From: William Savage <wsavage@acorn-engineering.com>
To: Jean Fraser <JF@portlandmaine.gov>
Date: 2/2/2016 8:23 PM
Subject: RE: 31 Fore St- Tech Std waiver
Attachments: 31 FORE ST - RESIDENTIAL MULTI-UNIT PREAPP.PDF

I did speak with Port City and they were very adamant that to meet the 35 ft setback in entirety would require a significant redesign of the building. We may be able to shift the driveway 6" up against the building and reduce the driveway width to 10 ft but in total this would only gain us 1'-6". We would be closer to 33 ft with these changes. Any plan changes would occur with our final submission and in either case we would still request a waiver although we believe we are meeting the intent of the technical standard. I will send along a separate email with our proposed waiver request. The request will not reflect the discussion noted above for our preliminary submission as this conversation is ongoing.

GARAGE PLAN
6 REG SPOTS

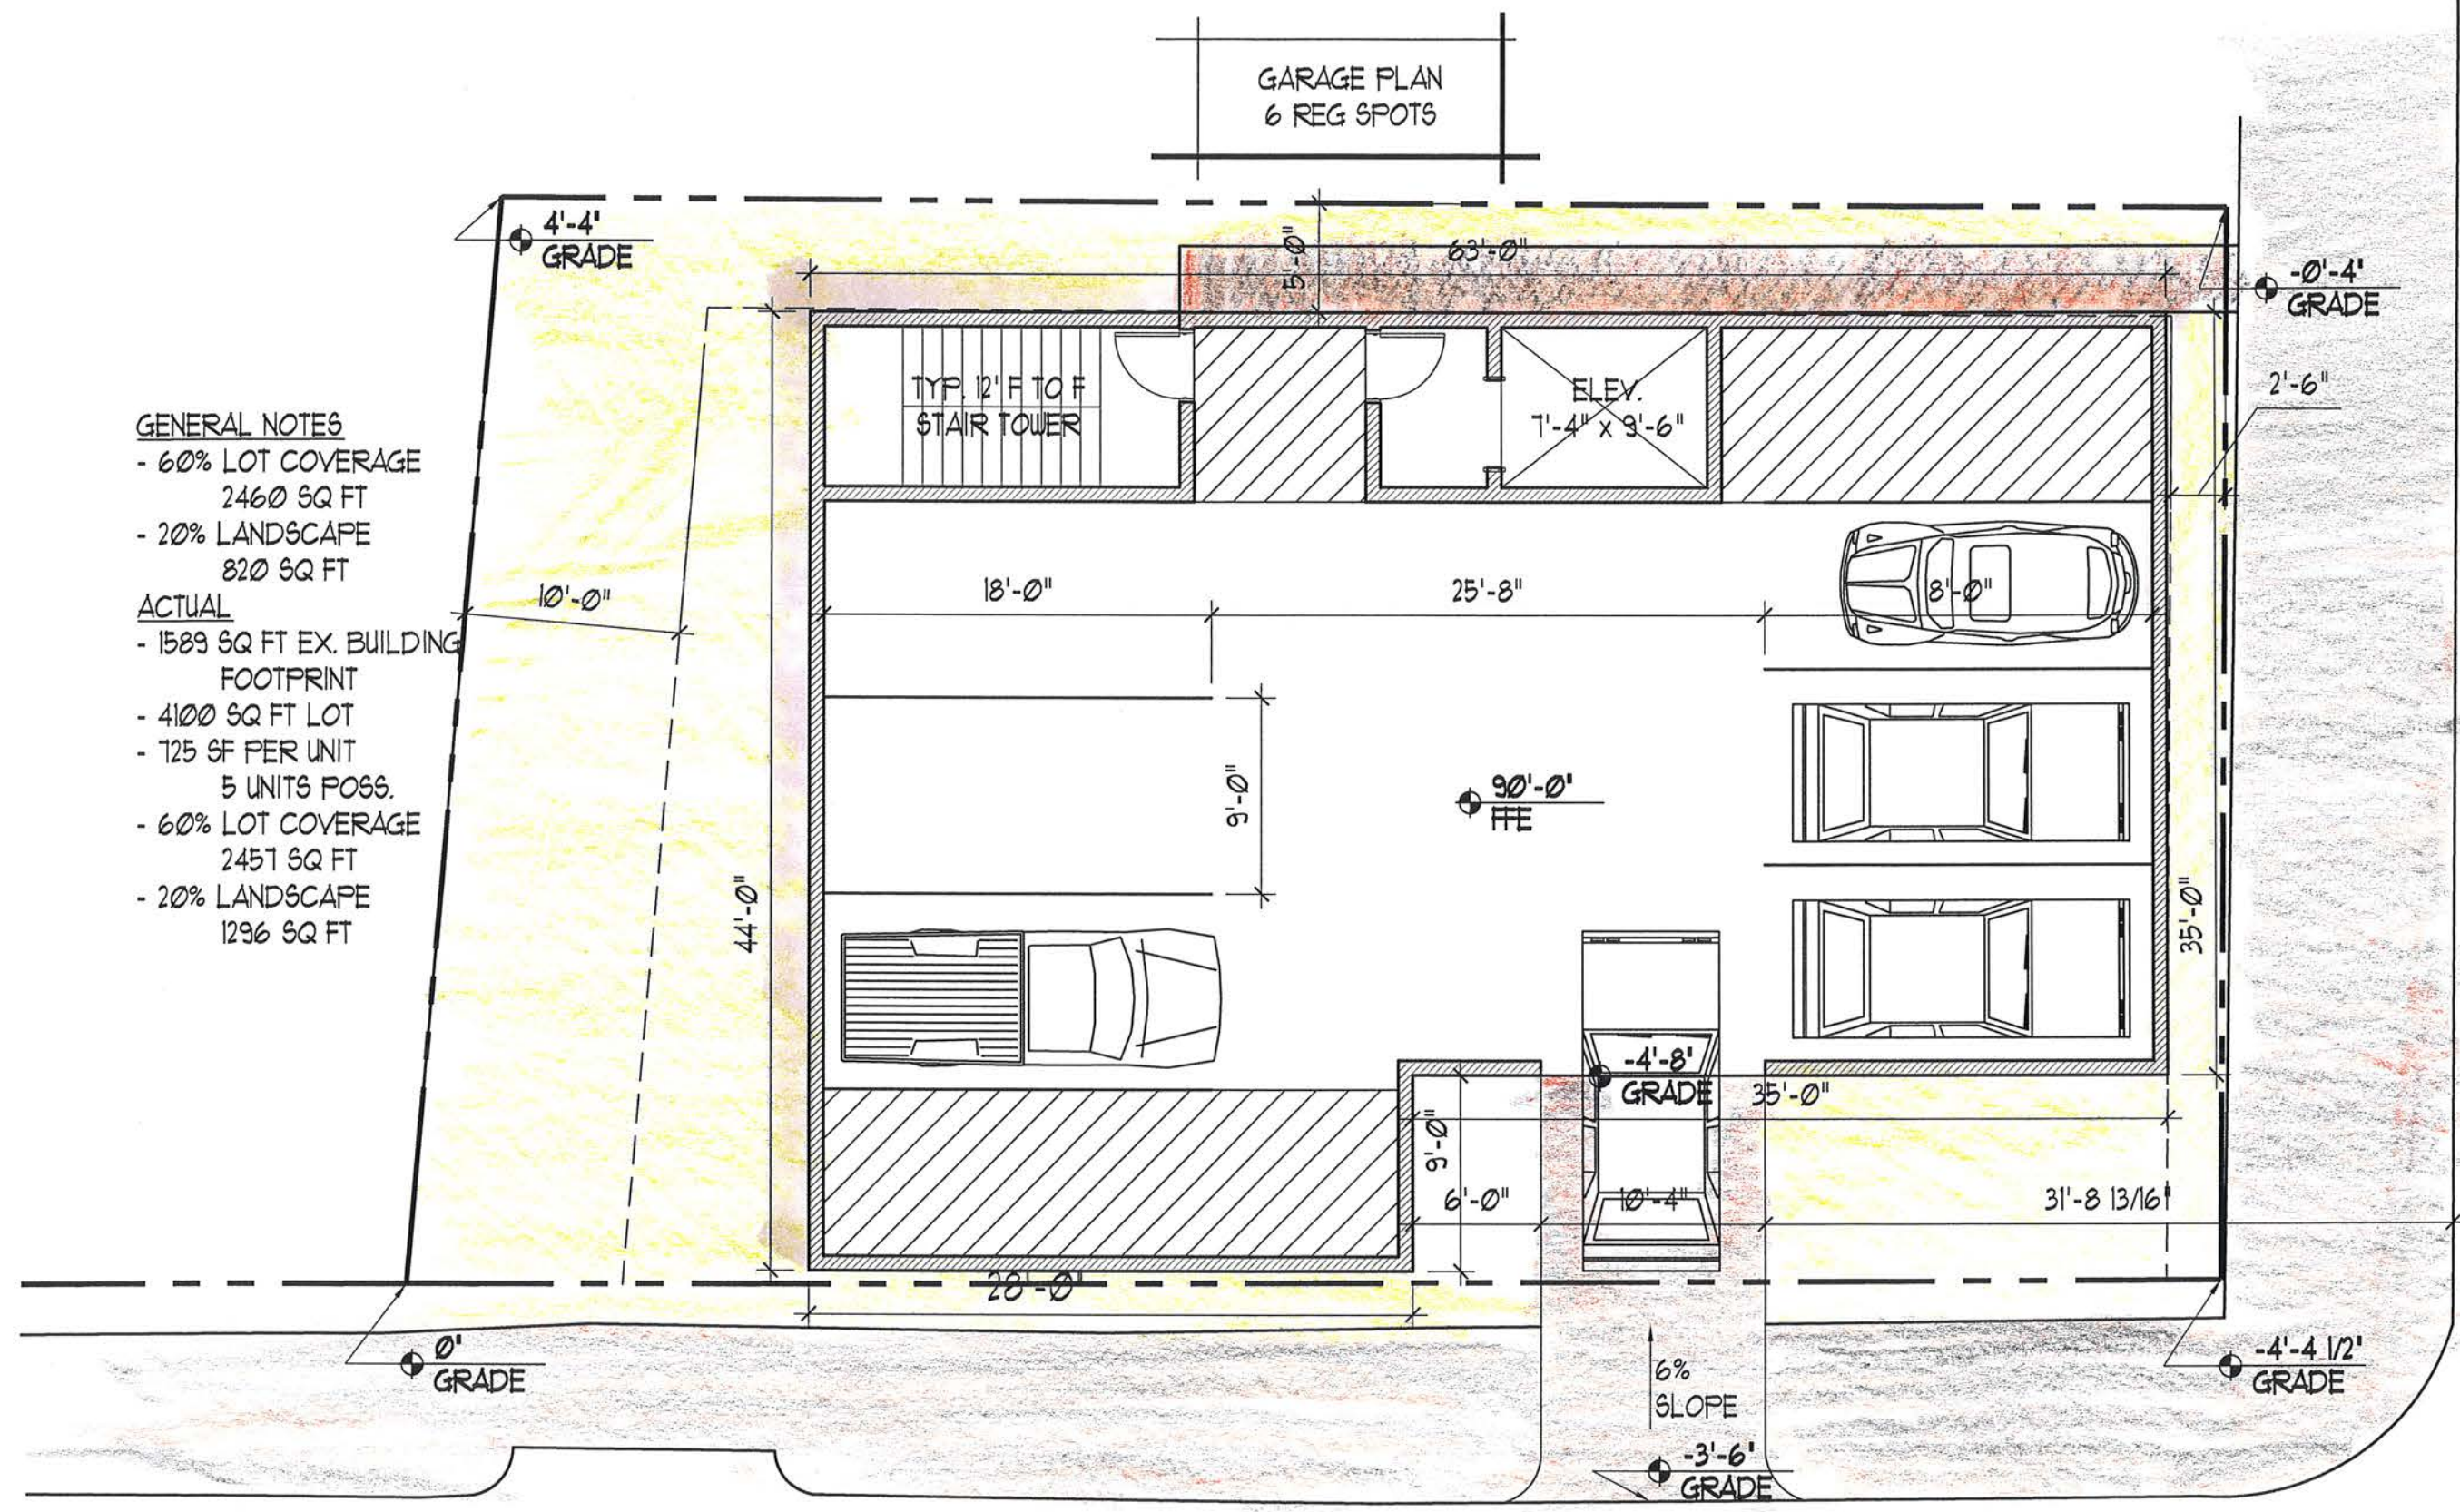
Please note that Port City has already shifted the driveway location once following input from staff on the pre-app meeting (I was not on the design team yet). They believe the present location reflects those discussions. Please refer to the attached plan that was submitted by Port City at the pre-app meeting for reference. Please note pg. 9 and 13.
